January 12, 2021
ES-6947.04

**Subject: Response to Comments
Proposed Marbella Residence
7311 West Mercer Way
Mercer Island, Washington**

Reference: Earth Solutions NW, LLC
Geotechnical Engineering Study
Project No. ES-6947.01, dated November 14, 2019

A2 STEPPED FOOTING AT SLOPED LOT
 SCALE: NTS

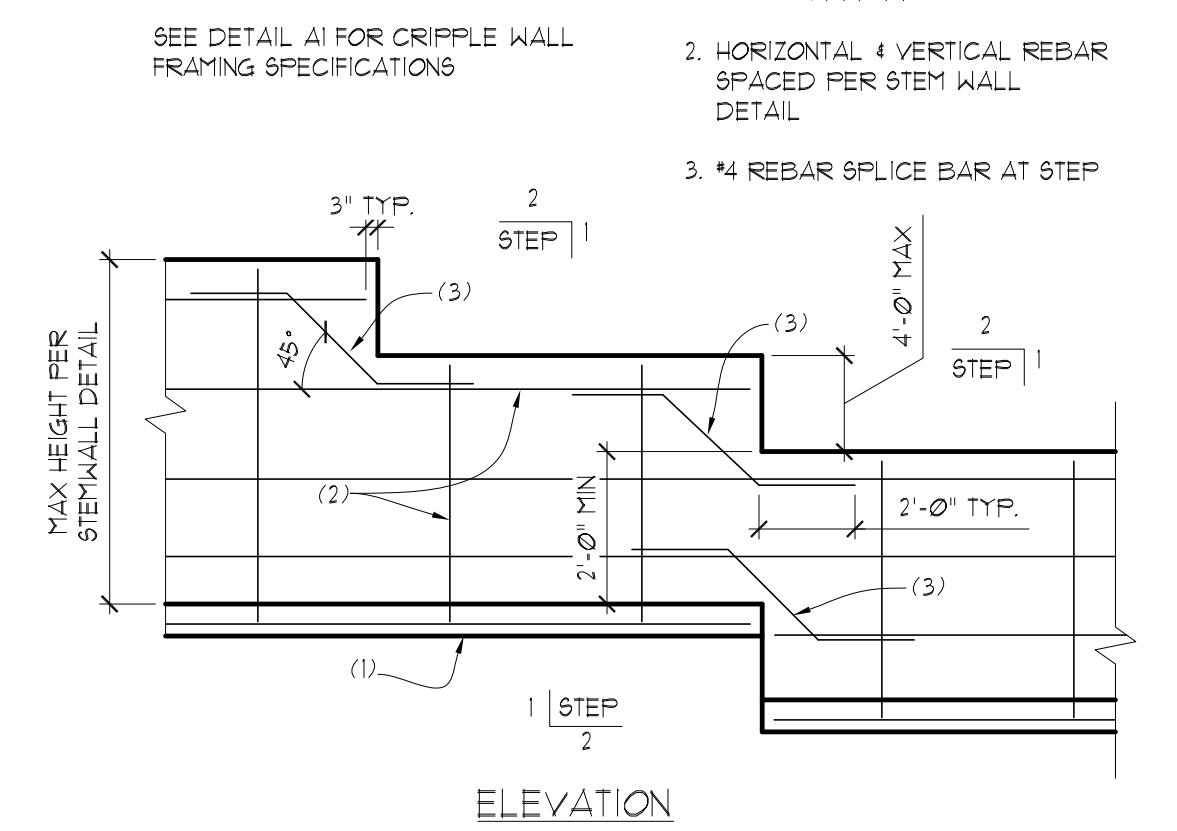
City Comment – Geotechnical engineer to provide recommendations for footings located on or adjacent to steep slope. Recommendations to include minimum embedment of footings with detail showing footing and slope for clarification and allowable soil bearing pressure given the presence of the steep slope.

ESNW Response – In our opinion, foundations near sloping areas should maintain a 10-foot setback from the slope face. This can be achieved by either constructing foundations 10 feet from the top of slope or advancing the foundation sufficiently to maintain a 10-foot horizontal setback between the foundation and slope face. Please see the attached Plate 1 (Foundations Adjacent To Slopes) for a depiction of these recommendations. Provided that competent native soils are encountered at subgrade elevations, the previously recommended allowable soil bearing capacity of 2,500 psf is considered suitable for design. Based on our test pit exploration, we anticipate glacial till to be prevalent throughout the area; as such, we do not anticipate adverse impacts to the slope during foundation preparation activities. ESNW should be retained at the time of construction and foundation preparation to observe field conditions and provide additional recommendations, where necessary.

**SITE PLAN**

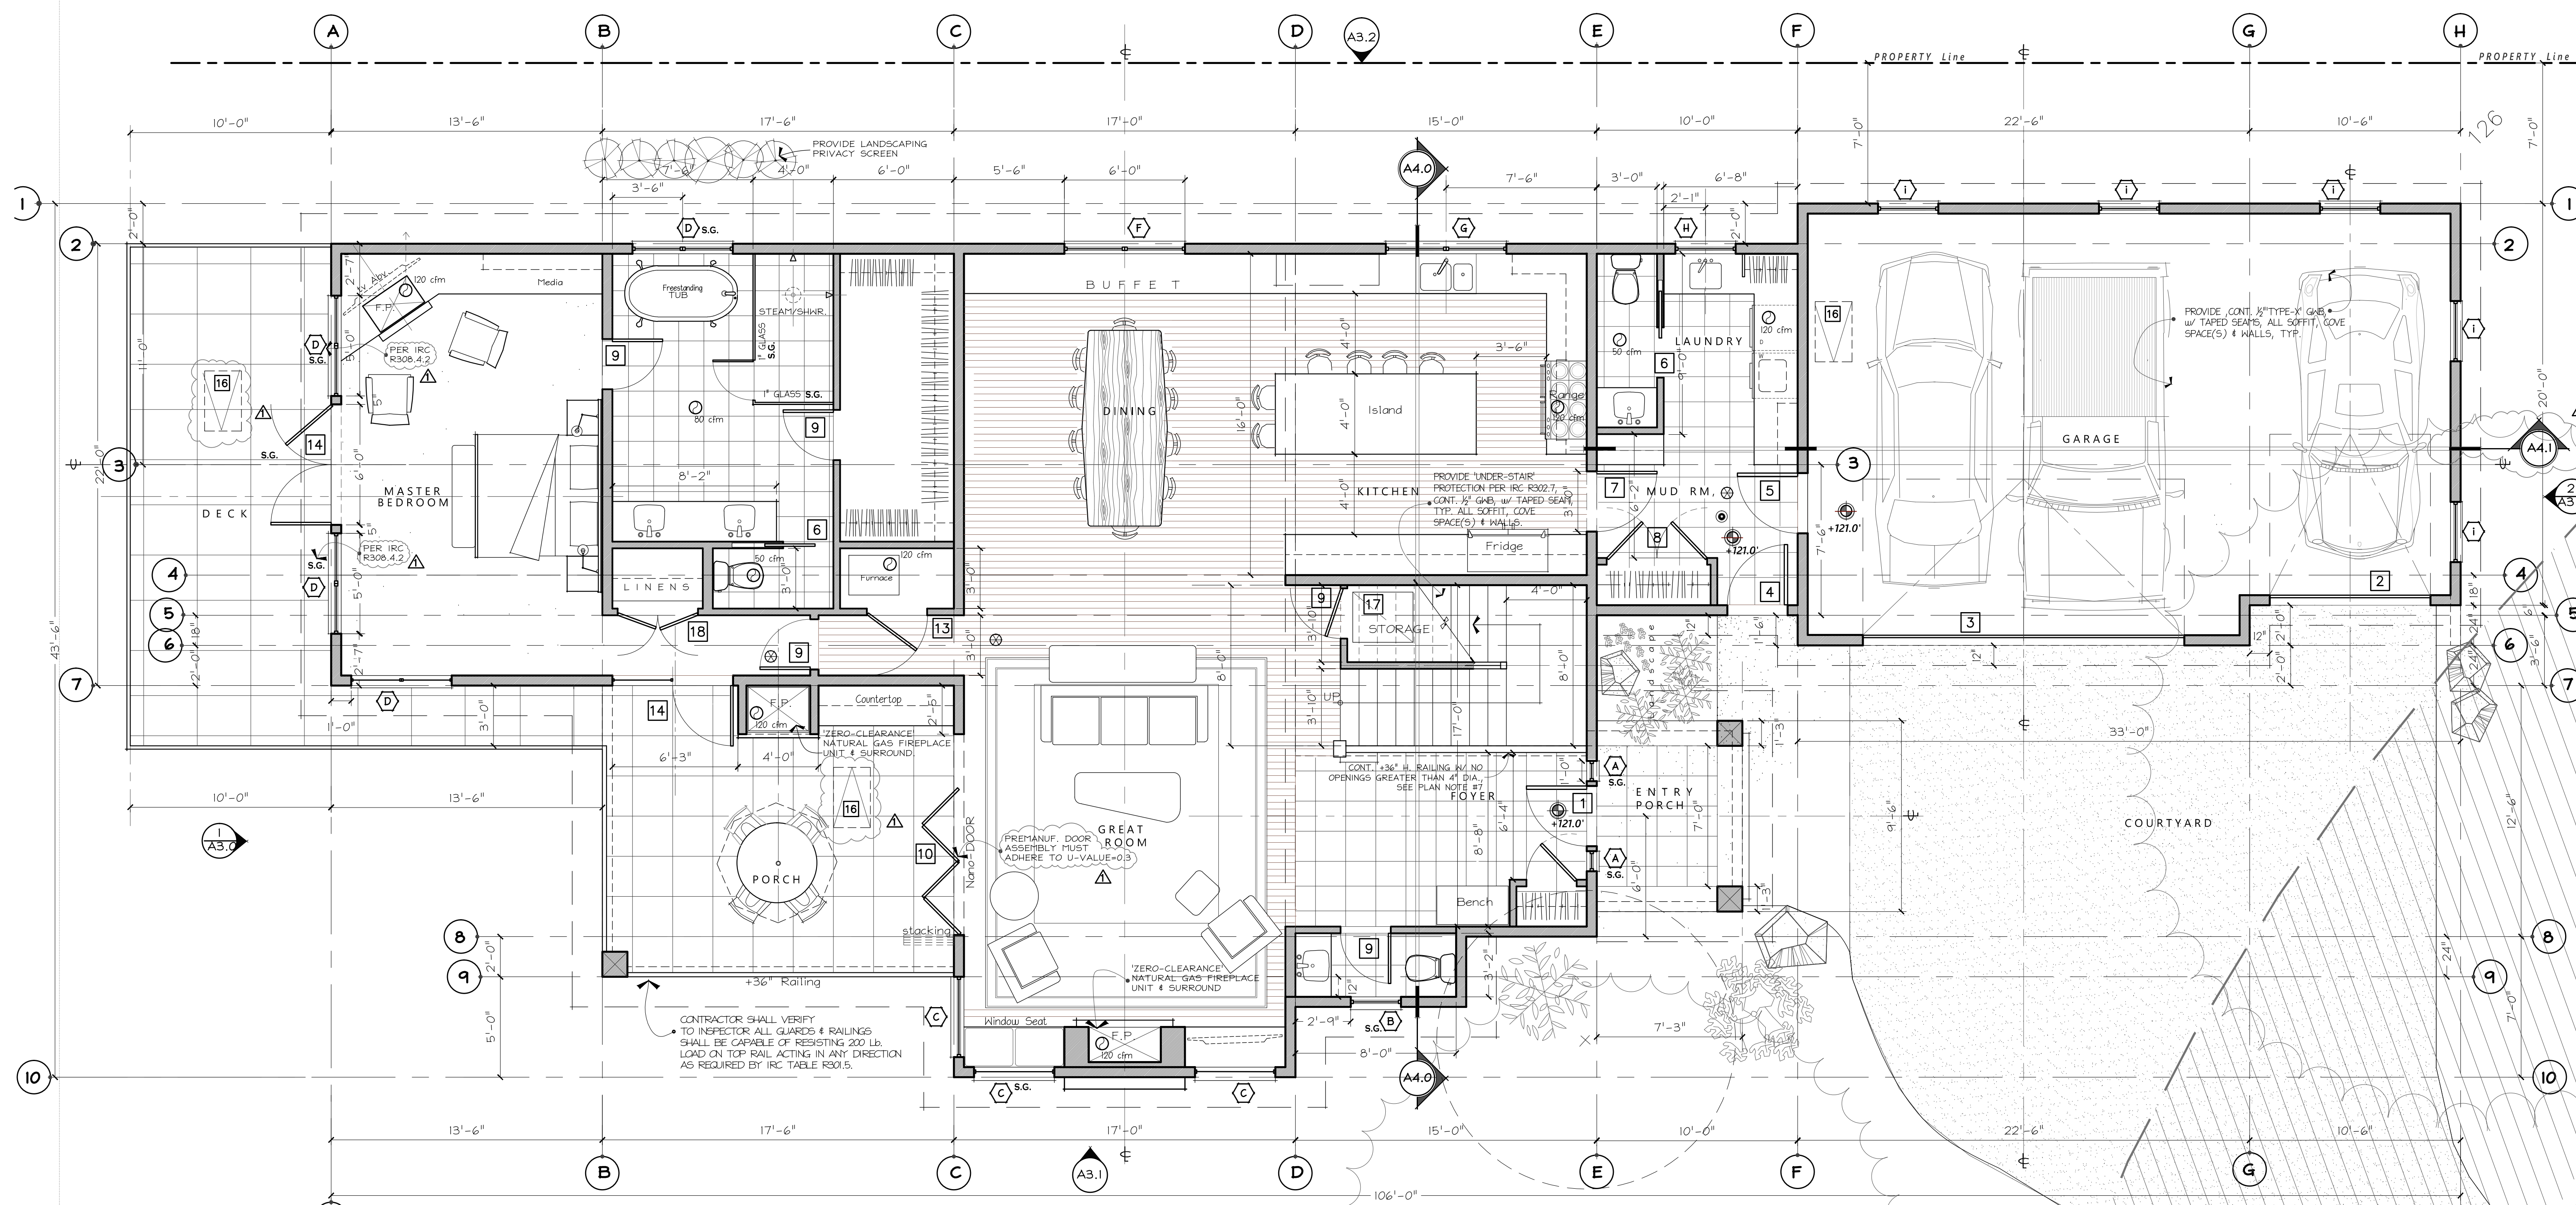
City Comment – Include note indicating that no excavated soil or removed vegetation will be allowed to remain on the slope.

**PIPE ANCHOR NOTES BY GEOTECH. ENGINEER**

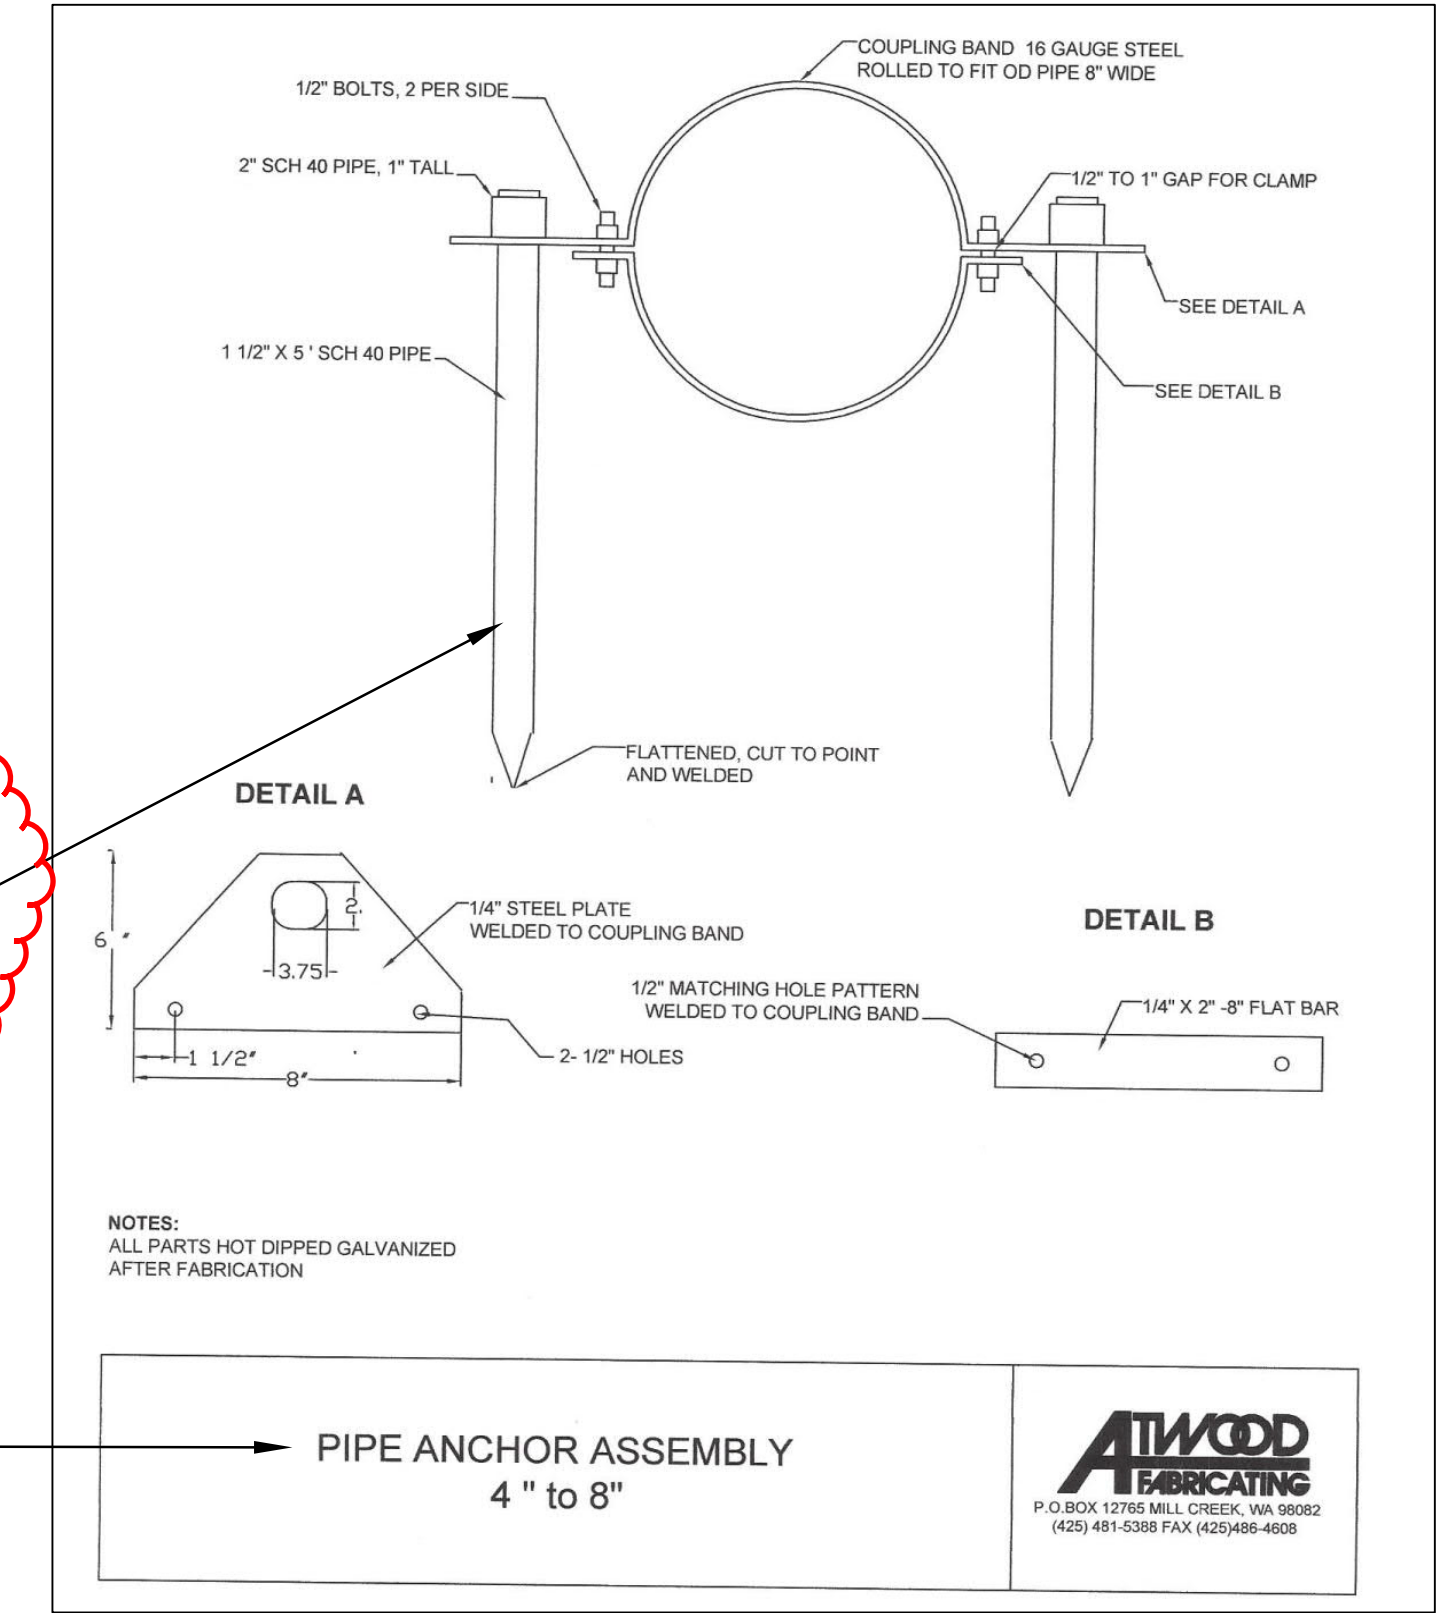
City Comment – Geotechnical engineer to provide specific recommendations including location, depth, and anchoring for installation of the storm and sewer utilities on the slopes. Include assessment of slope stability for these areas.

ESNW Response – The referenced plan set indicates that surface-mount anchors will be used to secure both the storm utility pipe and sanitary sewer utility pipe to the slope face. In our opinion, surface-mounting the pipes will provide the least amount of intrusion to the slope. The anchor system should consist of a clamp into which the pipe is secured. The clamp should then be secured to the slope surface by vertically driving two-inch pipe piles on either side of the clamp. In our opinion, the pipe piles should be driven to a depth of at least five feet below the slope surface. A hand-held, pneumatic hammer will likely be required to install the pipe piles. Surface-mount anchors should be installed for every 20 linear feet of pipe alignment that is placed on the slope face. In our opinion, both the storm and sewer pipes should be aligned perpendicularly to the existing topography, to the extent feasible.

The pipes should be secured with dead-man anchors placed at the top of the slope. As the plans suggest, the proposed catch basin can serve as a dead-man anchor for the storm pipe alignment. An ecology block or another similar concrete block can be used for the sanitary sewer pipe dead-man anchor.
